From: Wiles , Anthony (SENIOR CONSERVATION OFFICER)
Sent: 11 March 2020 16:19
To: Roddis , Rachael (PLANNING OFFICER)
Subject: RE: 2020/0239 Planning Consultation

DESCRIPTION:	Variation of condition 2 (approved plans) of planning permission 2018/0269 -Demolition of existing stables and hayloft and erection of detached dwelling
LOCATION:	1A Hopwood Street Barnsley S70 2BW
APPLICATION NO.	2020/0239

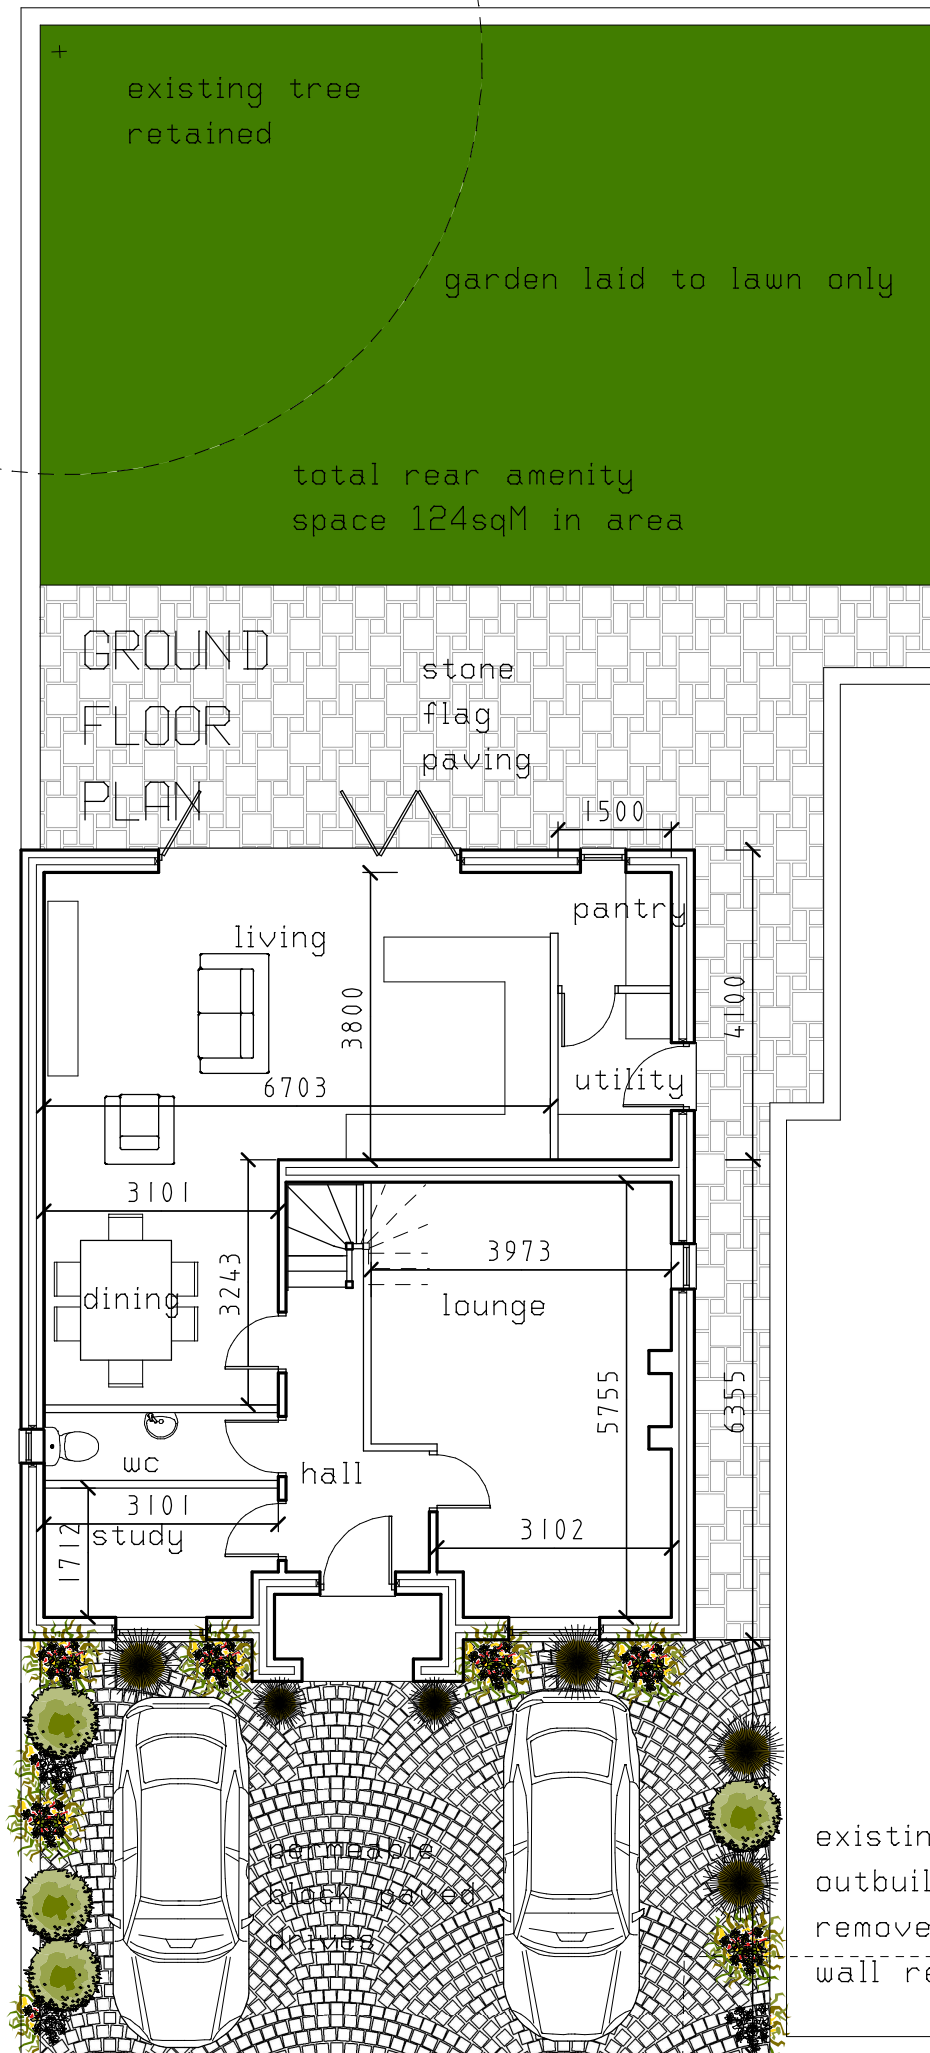
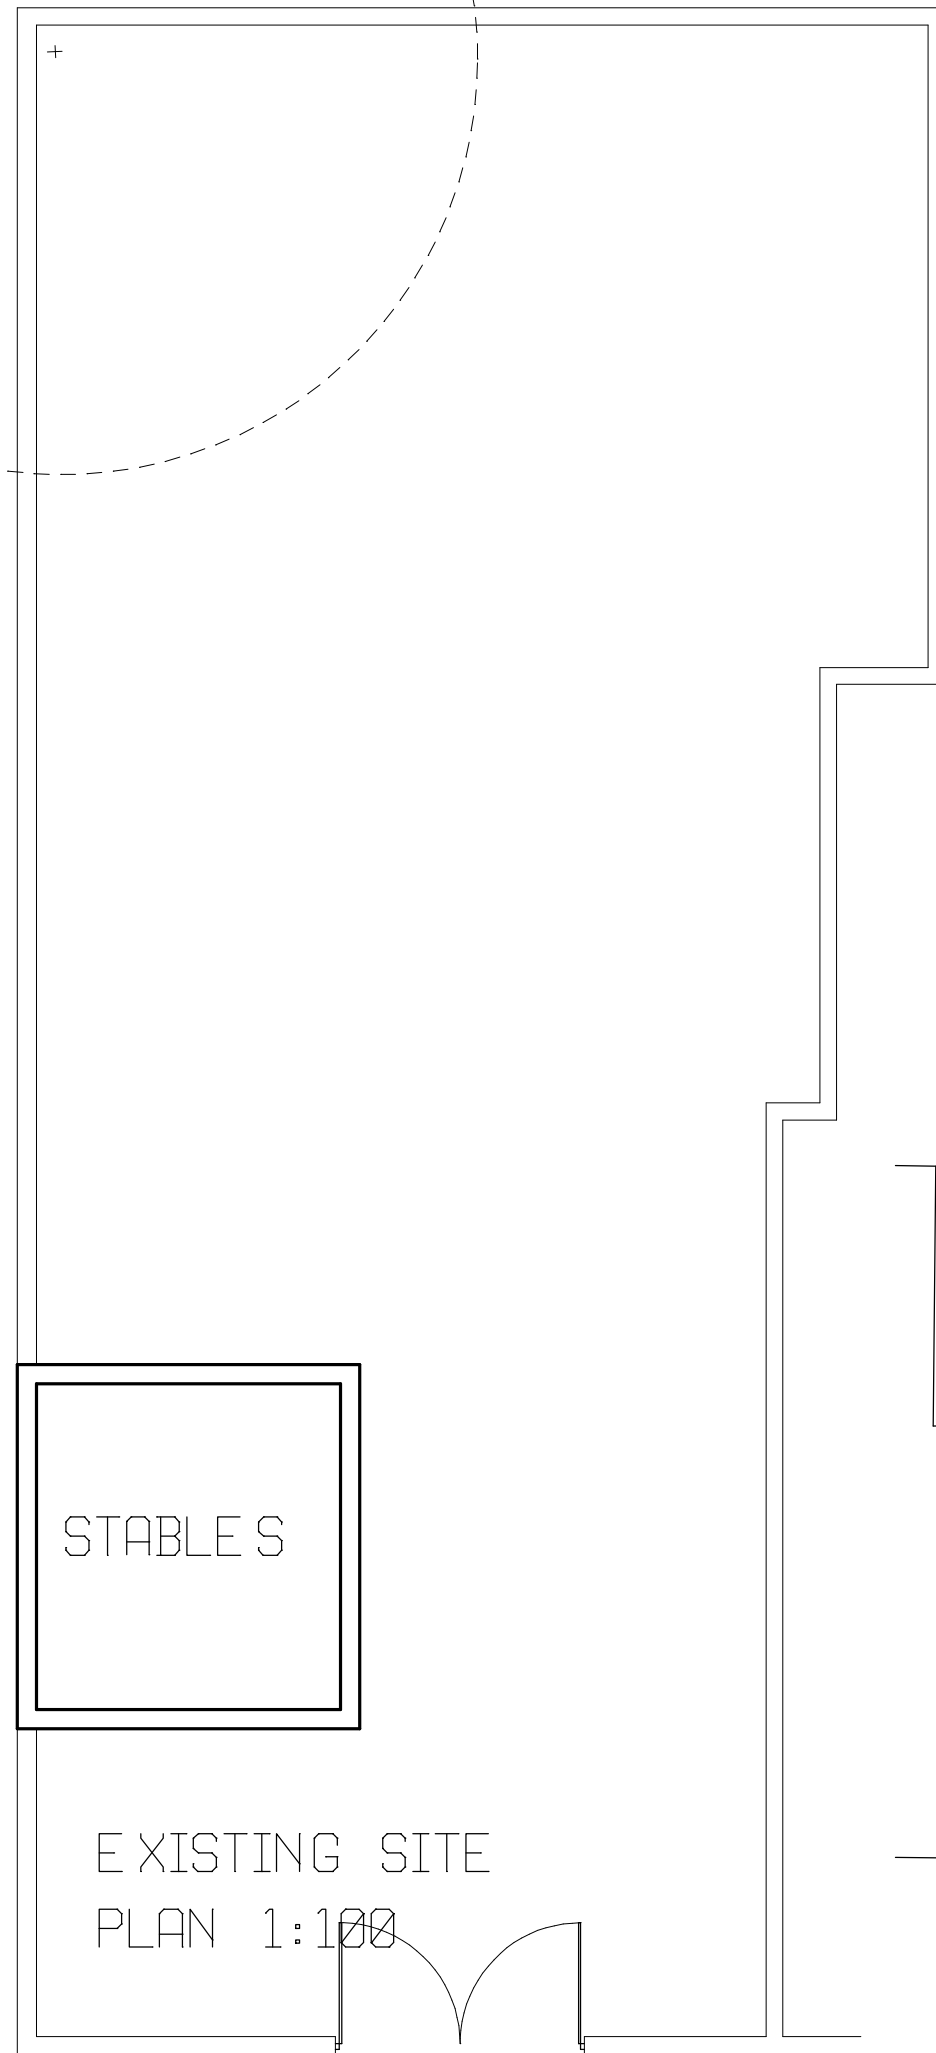
Rachael, I understand that the precedents cited are due to a lack of control we have over that matter for existing dwellings. However I know (because it has been repeatedly mentioned to me via the Civic Trust) that the removal of garden space and the imposition of front of dwelling parking is felt to denude the quality of the CA and the streetscene. Whilst I accept what the applicant says about the precedents this is a new development in a conservation area. As such it should aspire to a high quality front of dwelling boundary treatment typical of the Victorian properties that add to the group value of the conservation area and landscaping befitting of the locality.
